PLANNING AMENDMENT

Application No: HOS-0535-11 | A1

Description: Erection of one 10kw wind turbine

Amendment: Revised site plan (dwg. no. T004.001A)

Drainance Survey (c) Crown Copyright 2011. All rights reserved. Licence number 100020449
 Location Plan - 1:2500

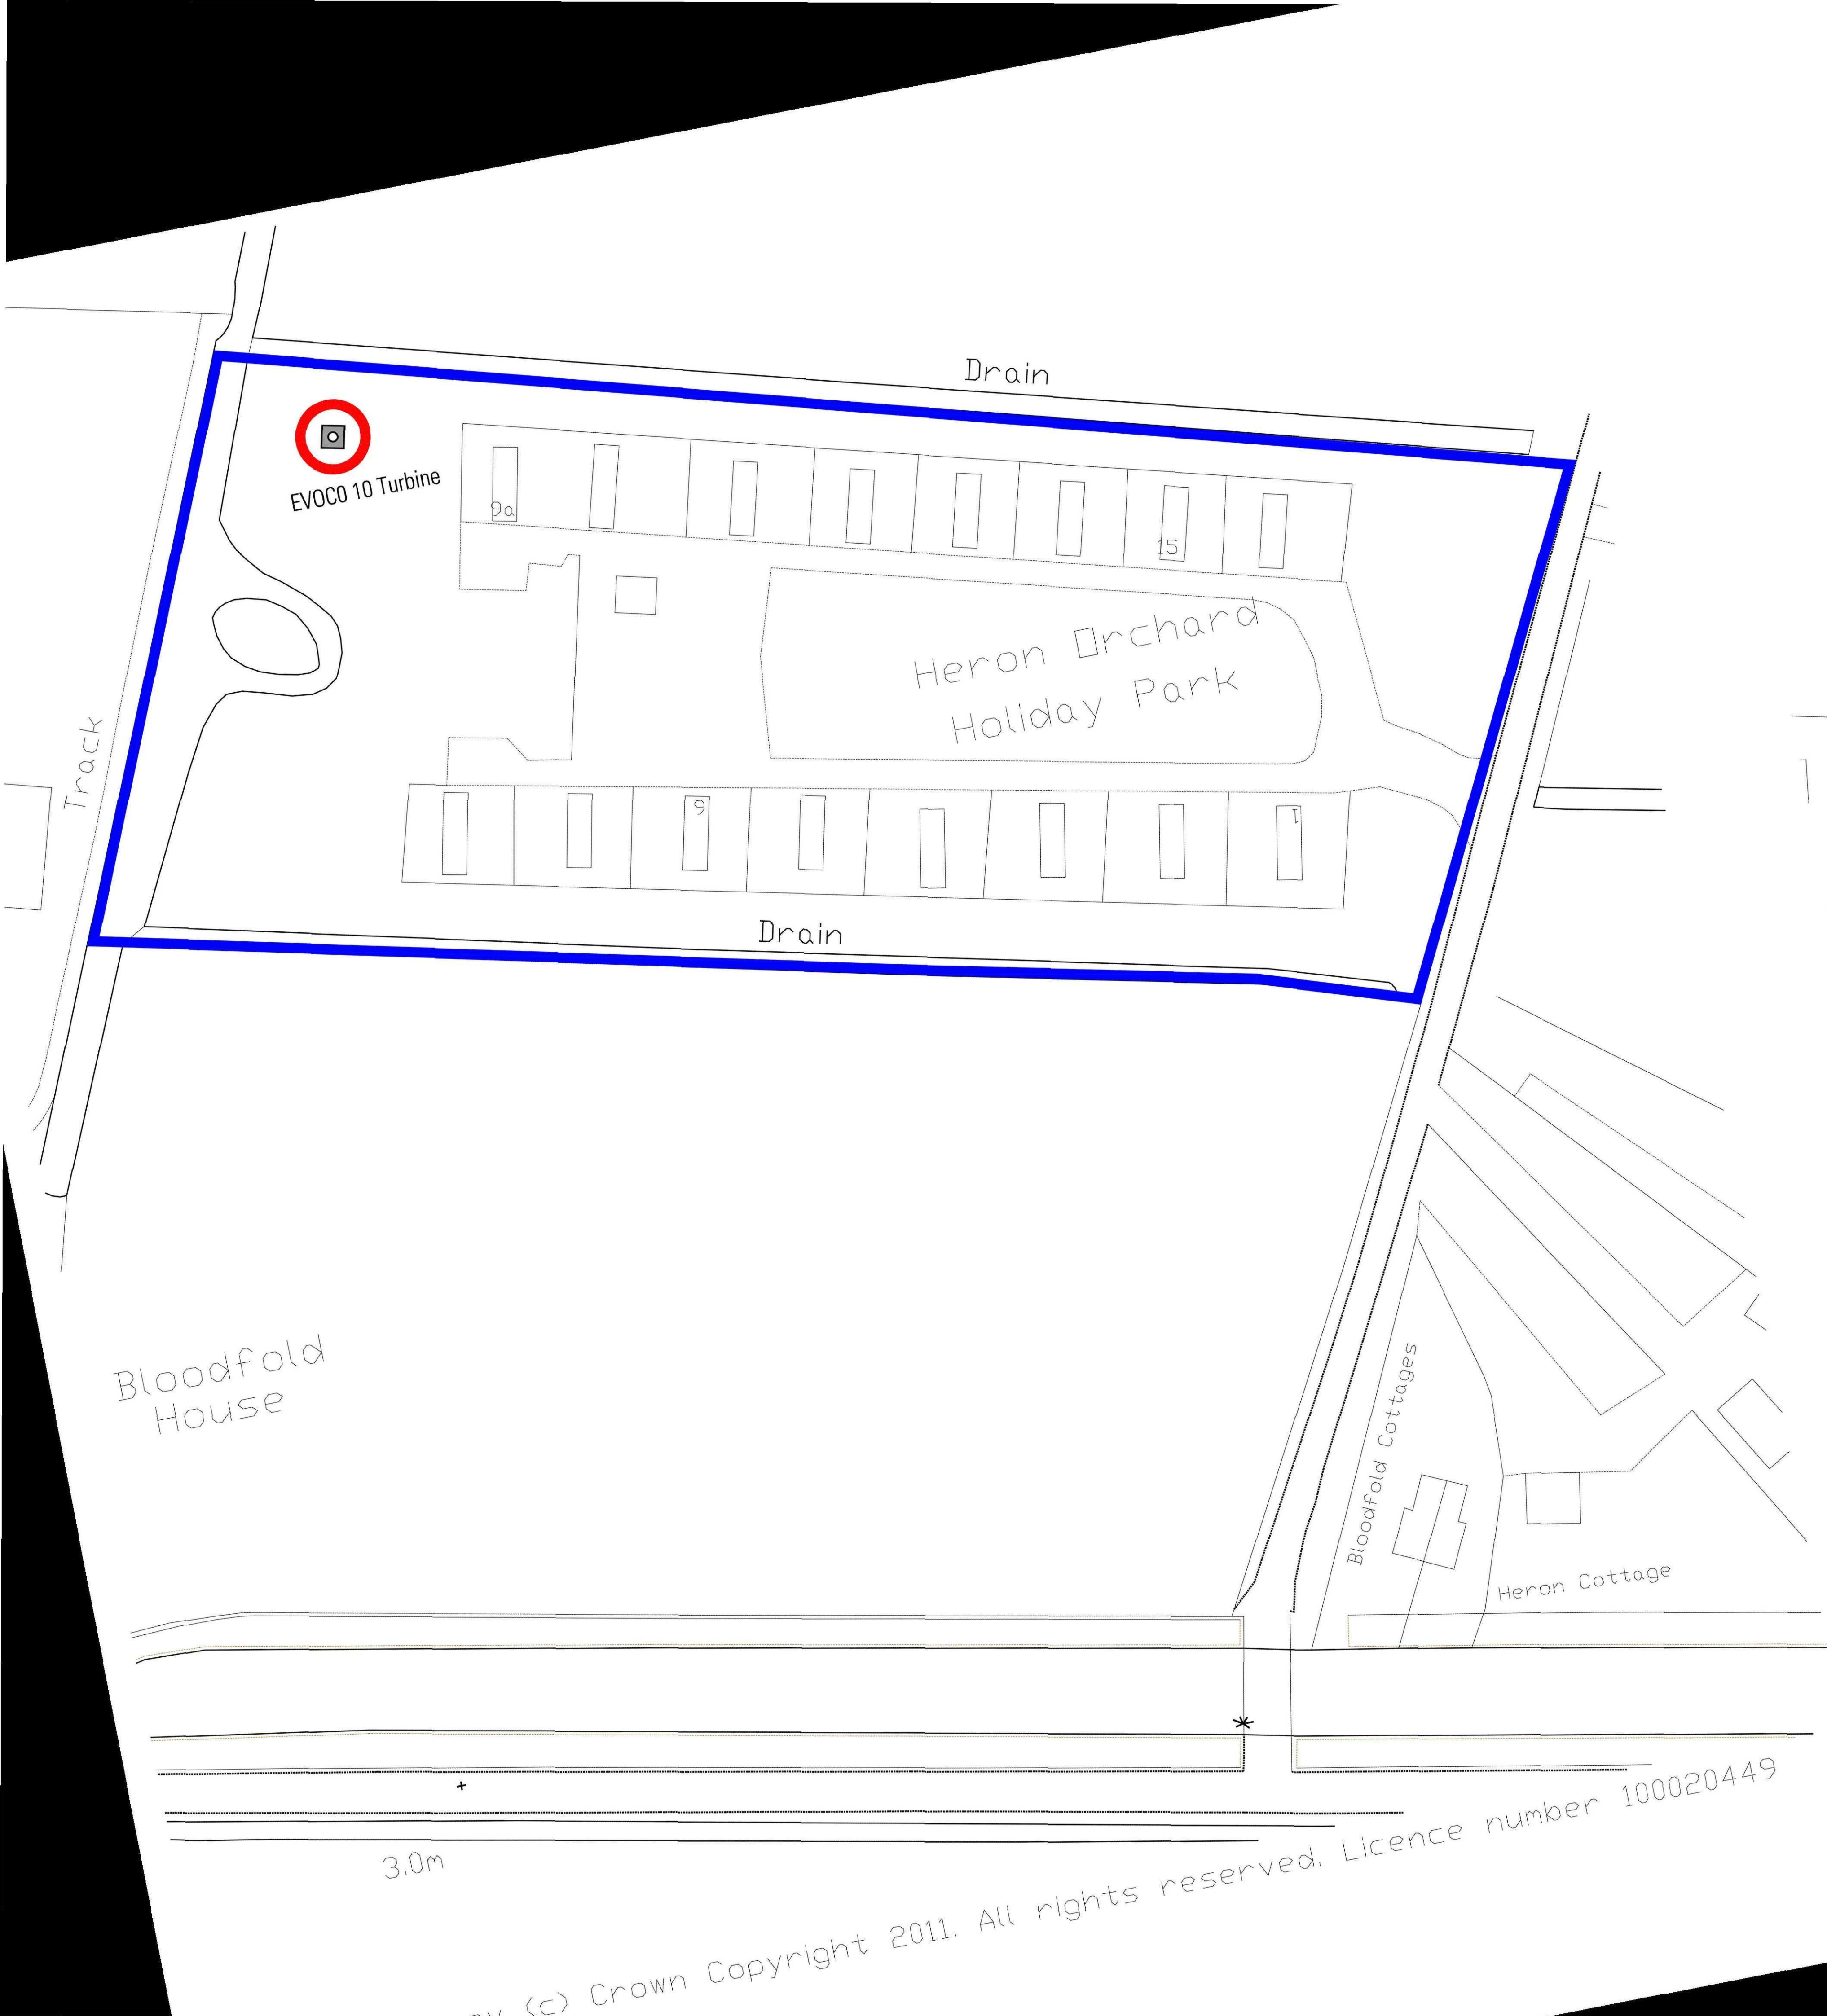
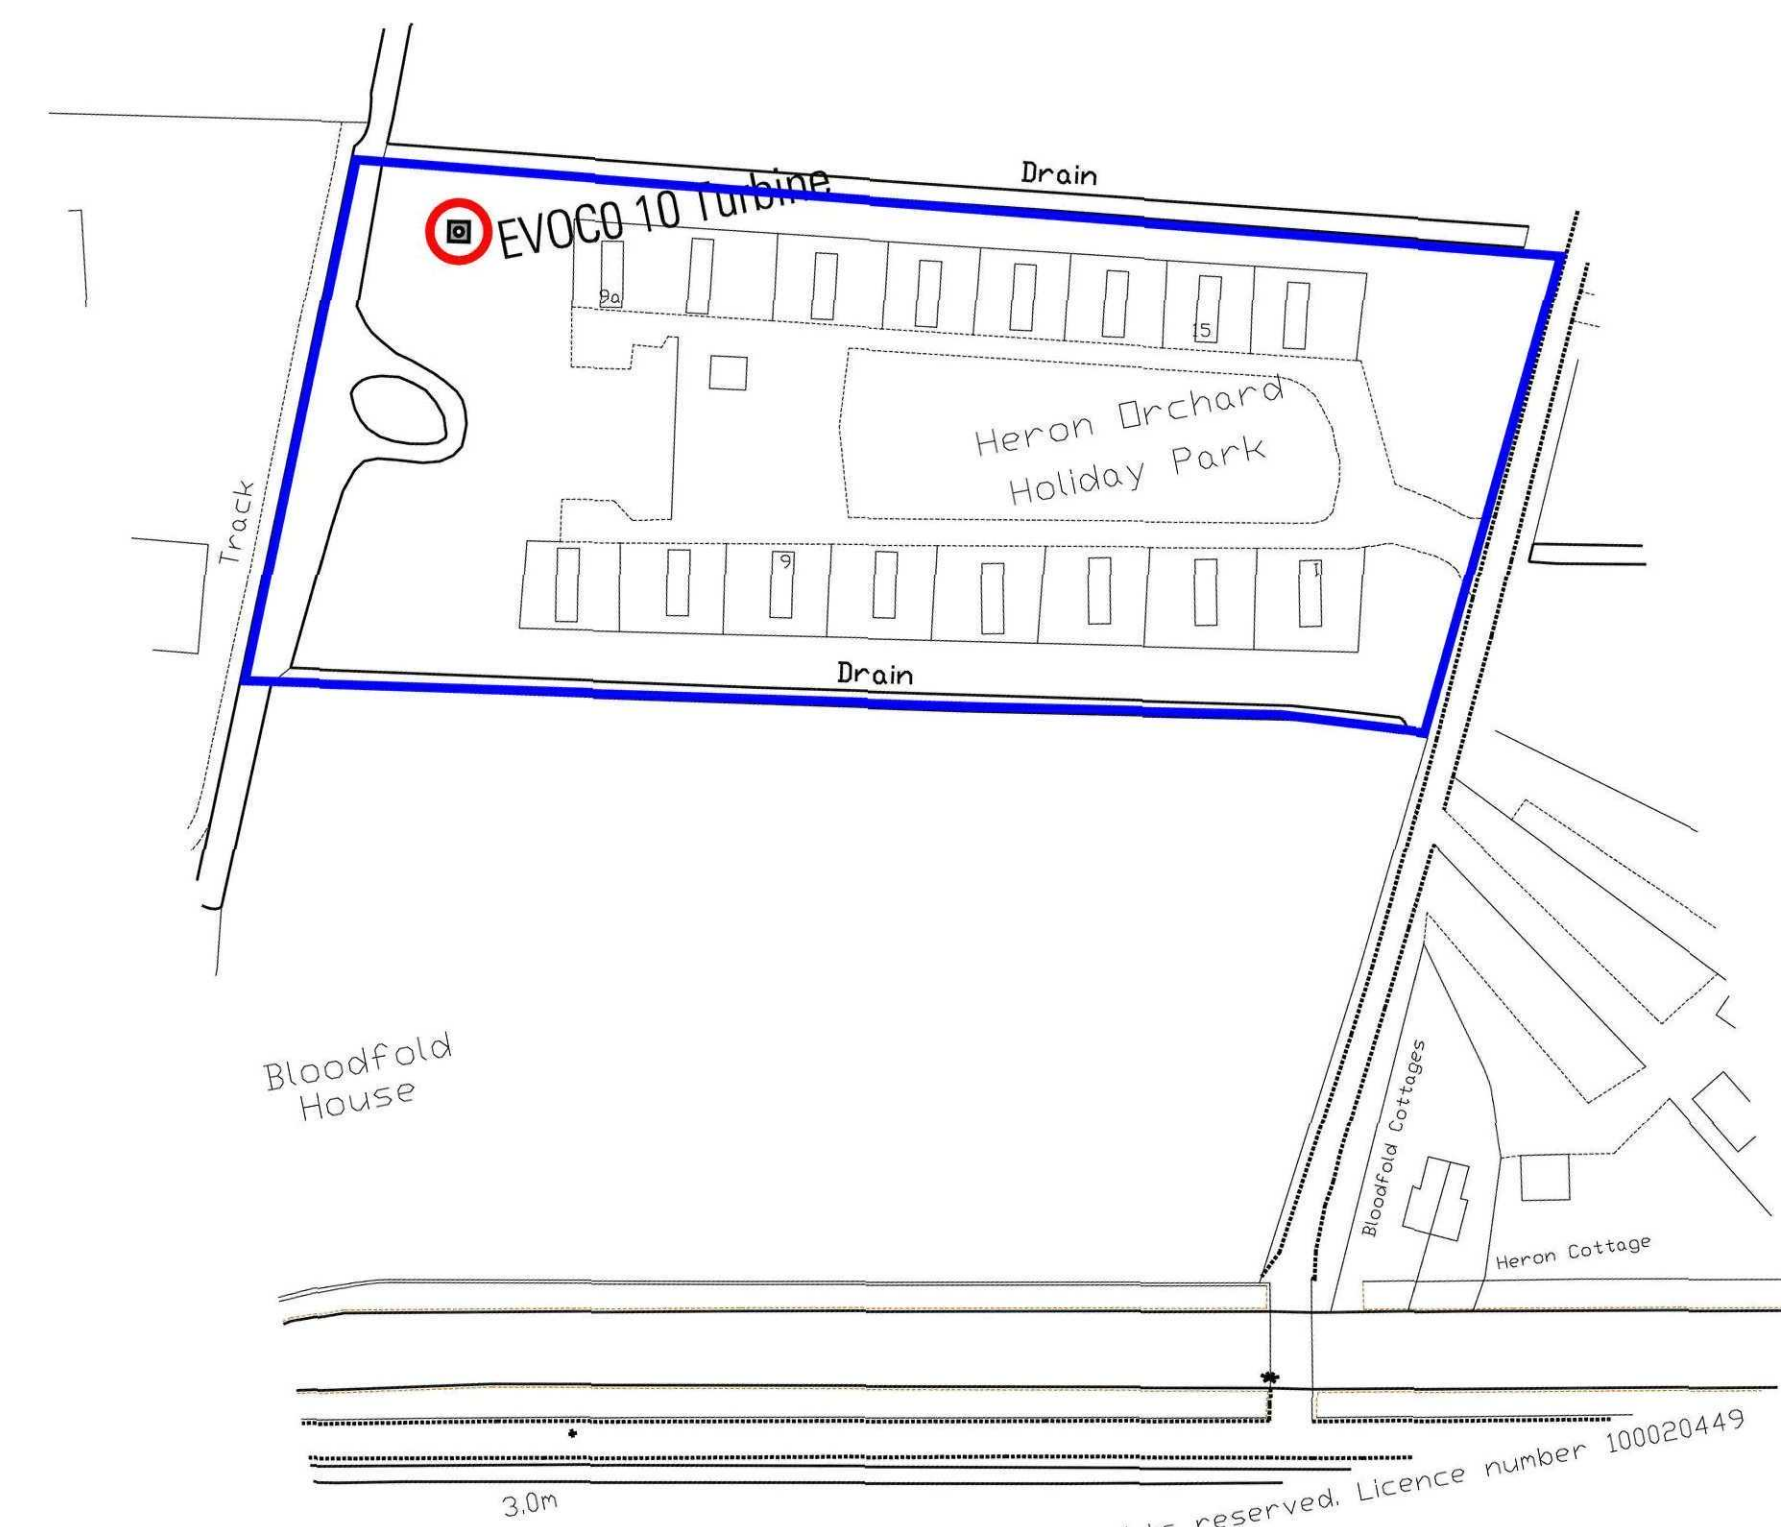
Attached revised site plan
